RE: **502 Deering Center – Di Minimis Revisions Memo #1 – 1st Floor Commercial Only**

From: Denis Lachman and Kiya Smith, Applicants

This memo describes di minimis revisions at the 1st floor commercial use only, and associated topics such as parking - for your review. The topics and revisions are presented in the following outline:

1 1ST FLOOR PLAN
SCALE = 1/4" = 1'-0"

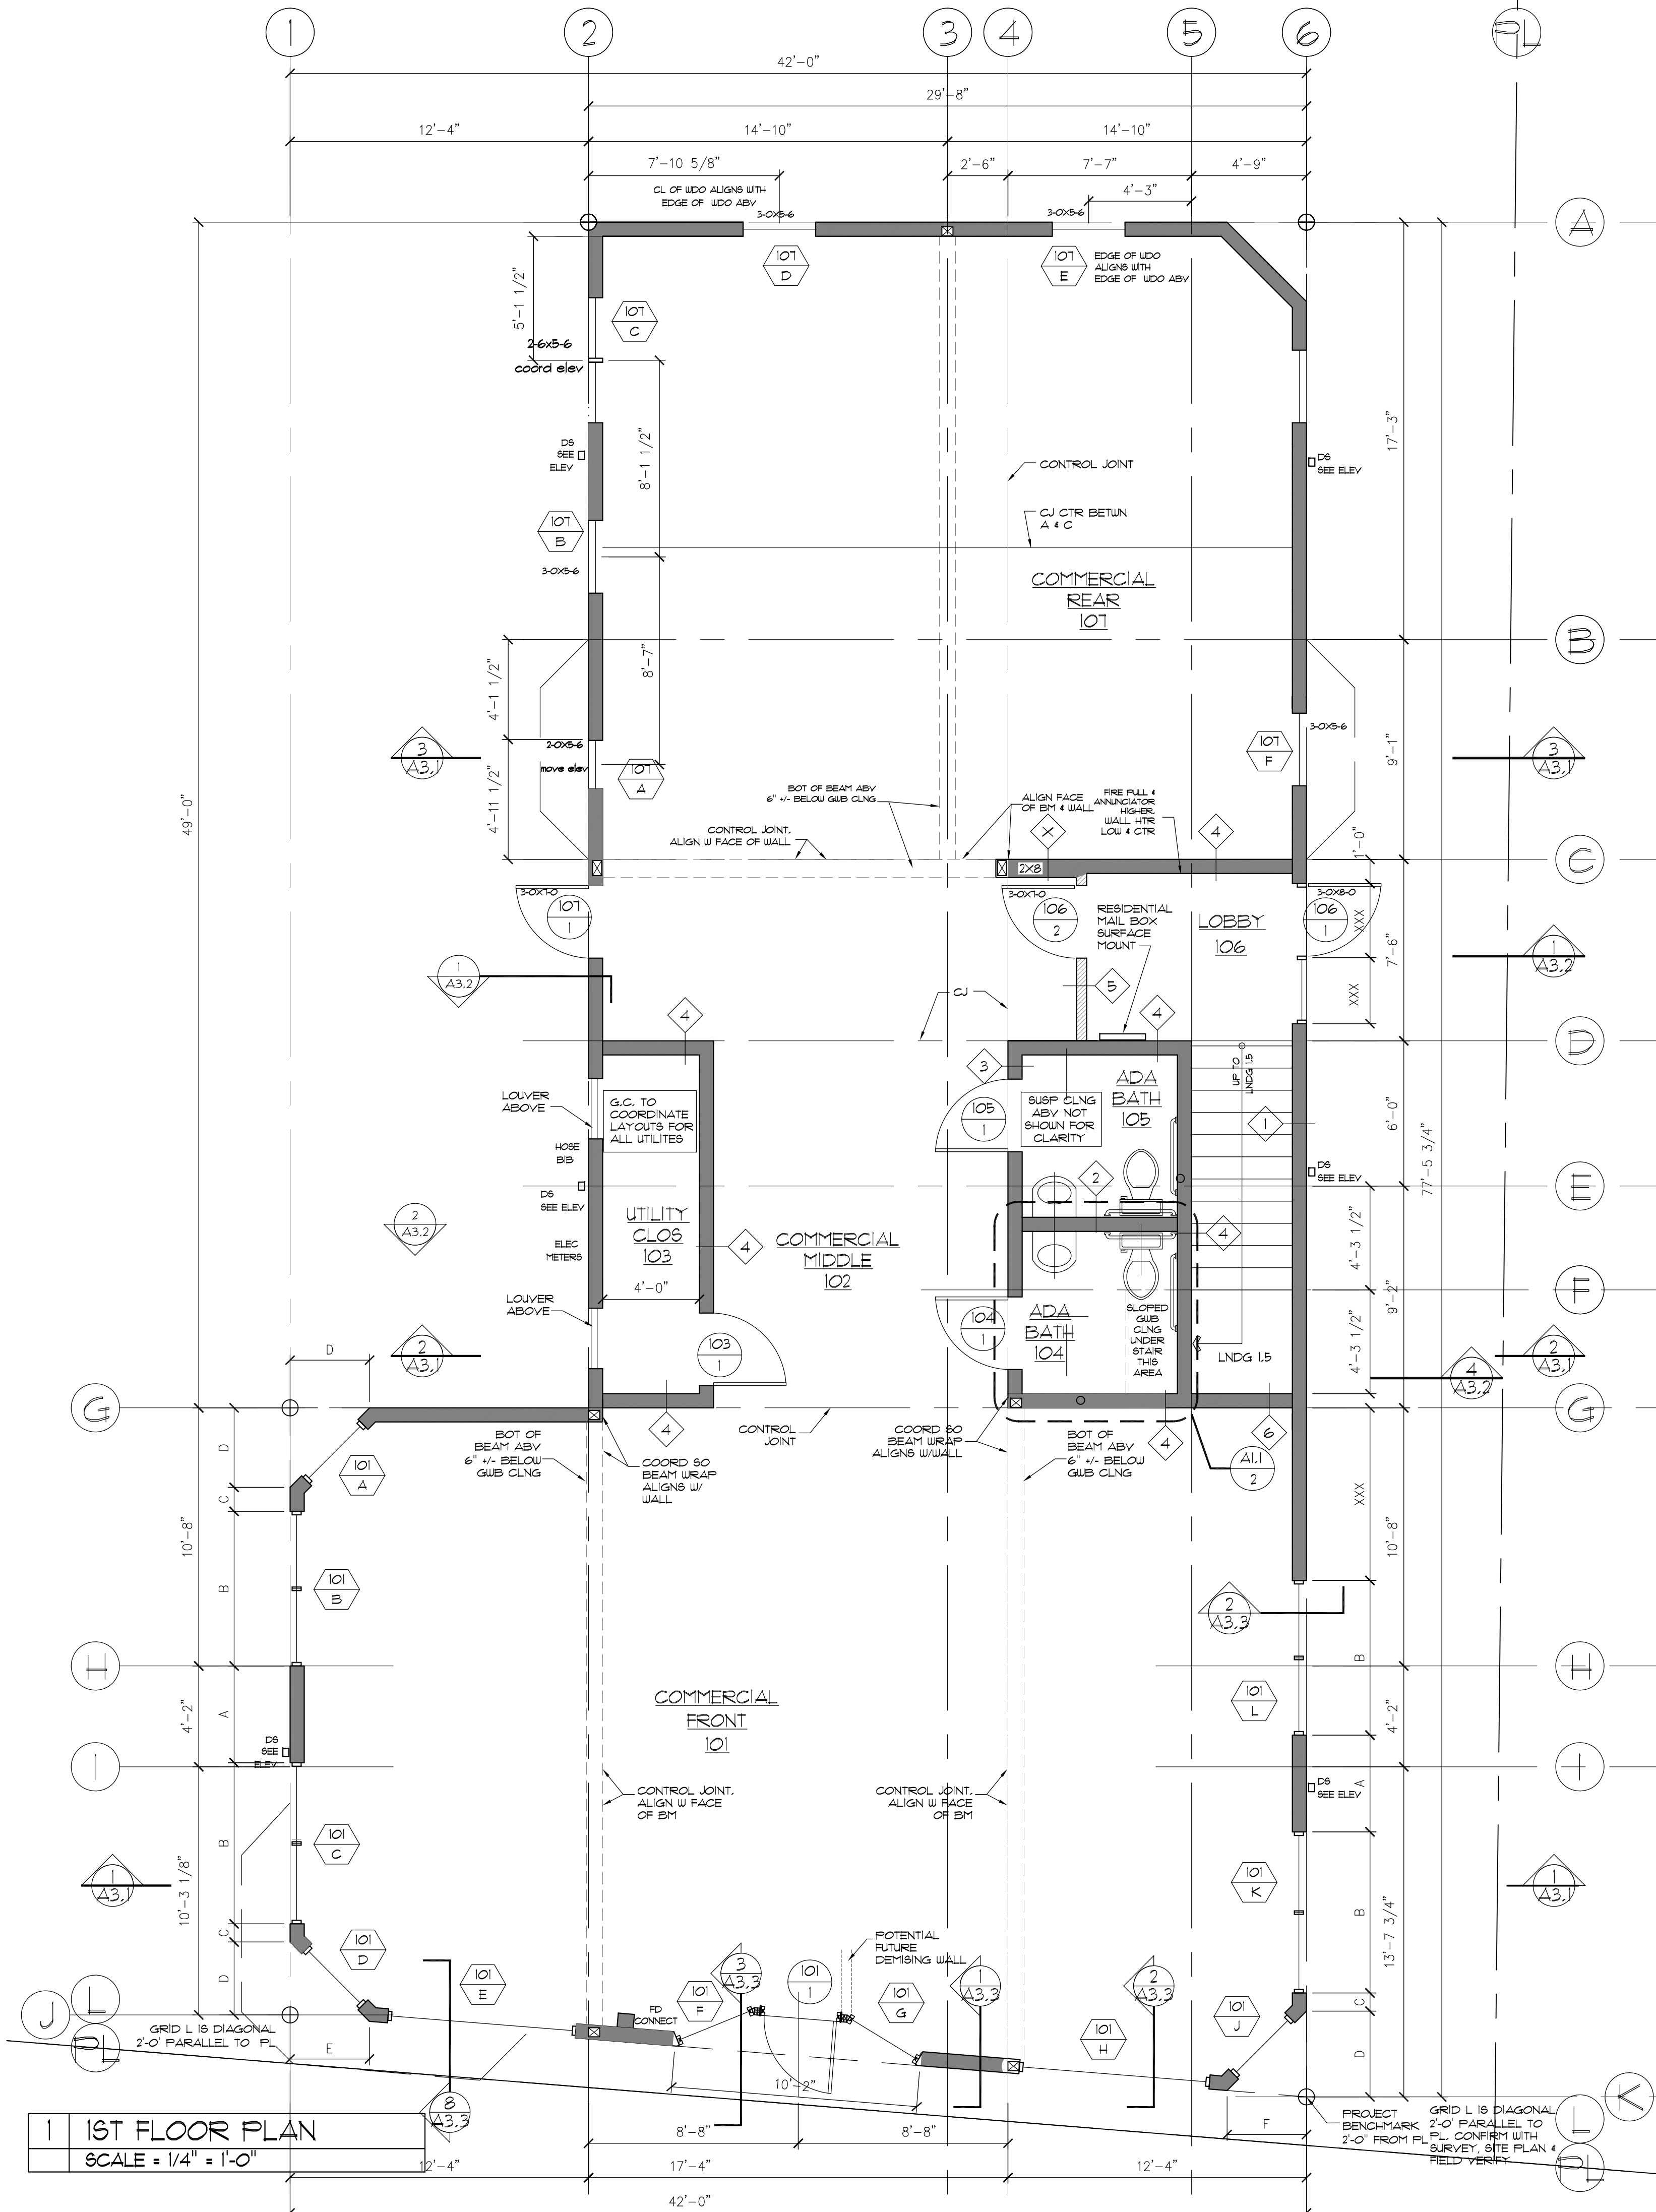
1. Reconfigure Commercial Space to Accommodate 3 Small-scale Tenants

The Planning Board approved the project as a “6-unit residential development plus 1 commercial space”. The approved single commercial space was generic and purposefully designed with a centralized core to ensure maximum flexibility, so that demising walls could be added to create multiple tenant configurations such as “(1) front & (1) back” or “(2) front & (1) back”. We have advanced from Phase 1 (planning, design and construction) to Phase 2 (marketing, leasing, tenant fit-out and occupancy) and have 3 tenants already. Consequently the single commercial space is reconfigured to accommodate 3 tenants. The establishment of smallscale ground floor commercial uses is highly consistent with the purpose of the B-1b Neighborhood Business Zone.

Previously approved – single tenant

Di Minimis Revision – three tenants

**1 1ST FLR @ FRONT
CORNER UNDER BAY**
SCALE = 1" = 1'-0" PLAN

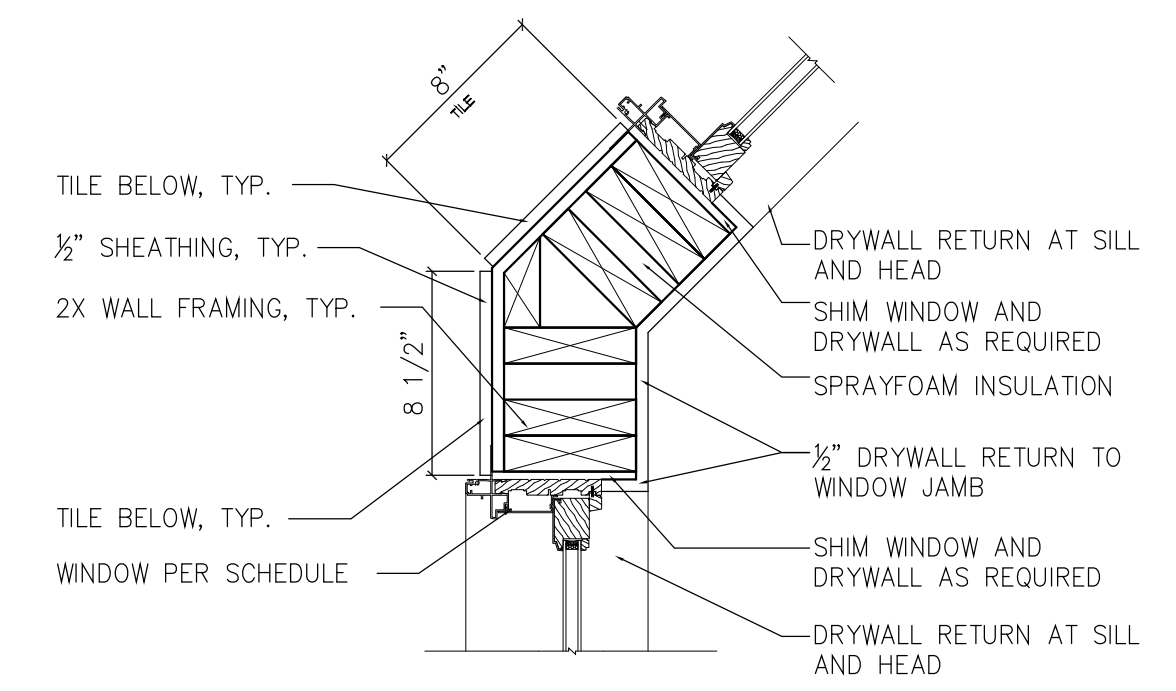
4. Front Entry Recess Reconfiguration

Purpose & Description of Change: The previous approved entry was designed to accommodate a single front tenant. The entry was reconfigured to accommodate direct ADA compliant access to both 1A & 1B. There is no change to the width, depth or height of the entry recess. This re-configuration is completely consistent with and complementary to the design favorably and unanimously approved by the Planning Board.

Before re-configuration, recess angled & single door

After re-configuration, recess squared & double door
